### RE: Big Ridge Short Plat (SP-07-115)

The Kittitas County Community Development Services Department has determined that the Big Ridge Short Plat is a complete application and hereby grants **conditional preliminary approval** subject to the following conditions:

### ADDENDUM

**Project:** Big Ridge Short Plat (SP-07-115)

## BIG RIDGE SHORT PLAT

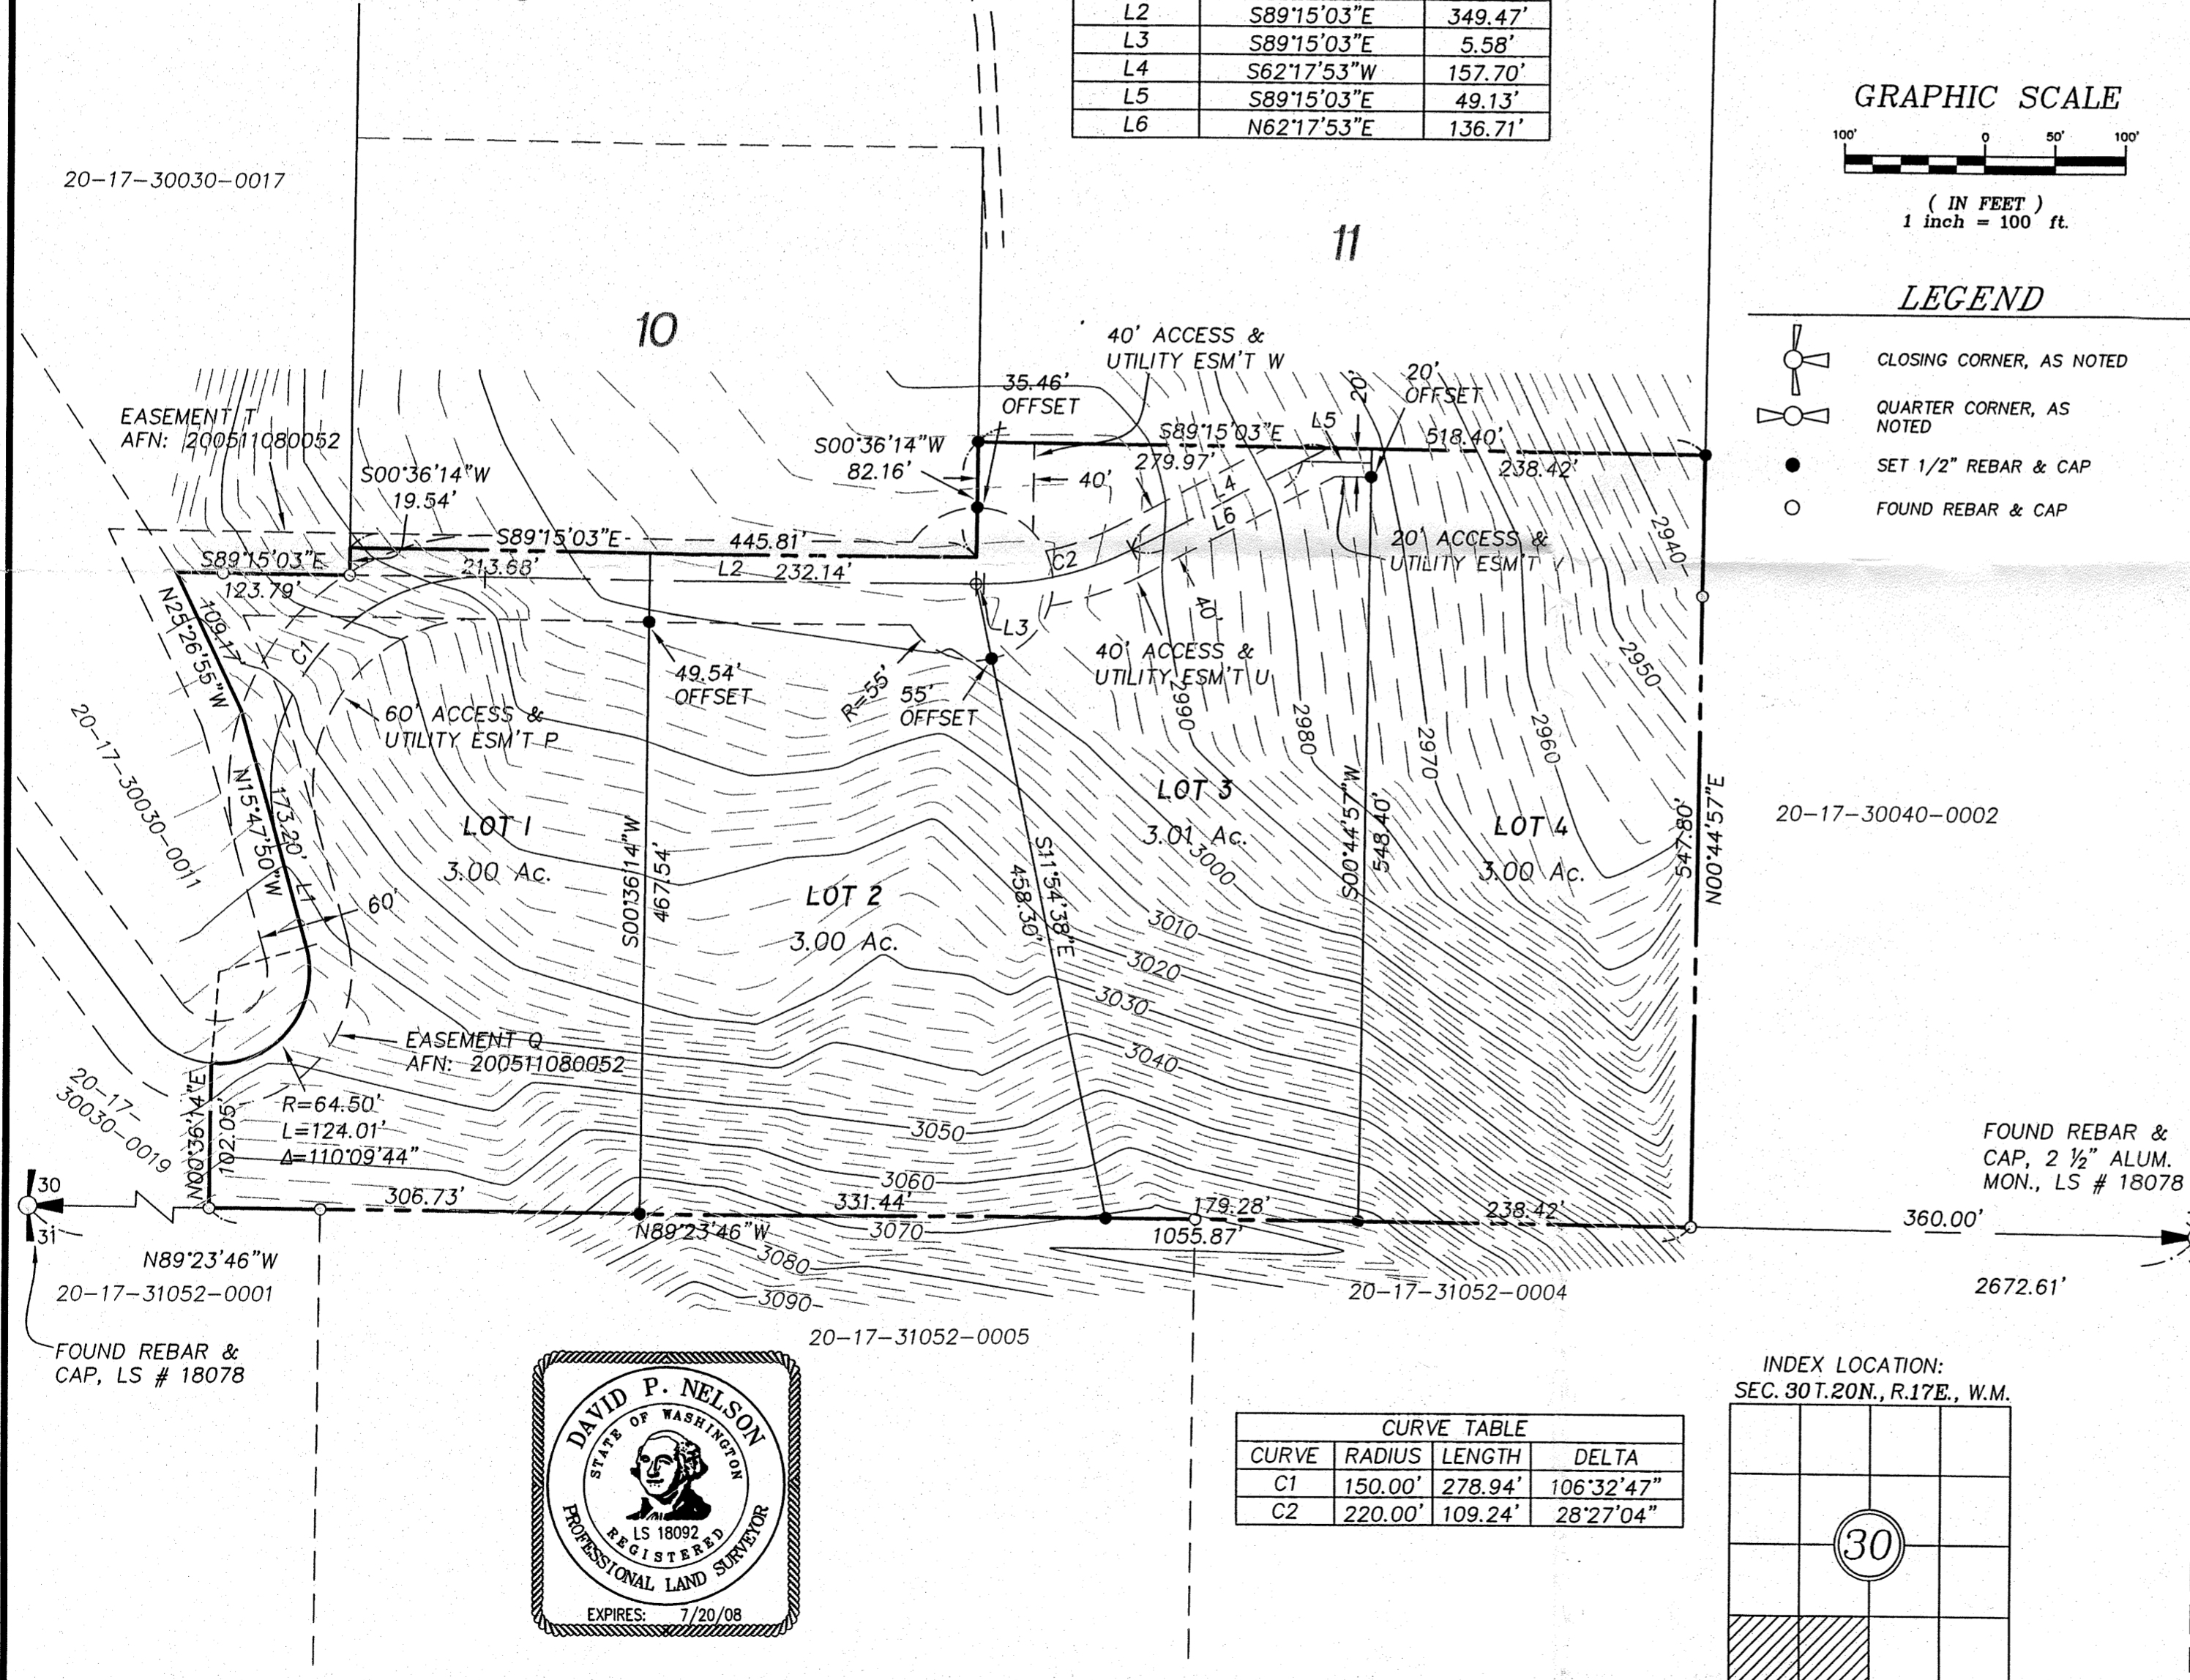
1. Both sheets of the final mylars shall reflect the short plat number SP-07-115.
2. All mitigations as set forth in the SEPA MDNS ADDENDUM issued on February 21, 2008 shall be conditions of approval and of the project. Please see the attached MDNS ADDENDUM.
3. A plat note shall be added as follows:

- B. As a condition of final plat approval, the previously recorded portion of easement "Q" connected to SR-970 at milepost 6.99 is no longer valid and is required to be removed. There shall be no access to the plat at milepost 6.99 on State Road-970.

- C. All access to the plat from SR-970 shall be at milepost 6.90, south of the Teanaway Road intersection (easement "R").
- D. The applicant will provide a safe location and passageway for a school bus stop. The local school district shall be consulted regarding the location and it shall be shown on the final mylars.
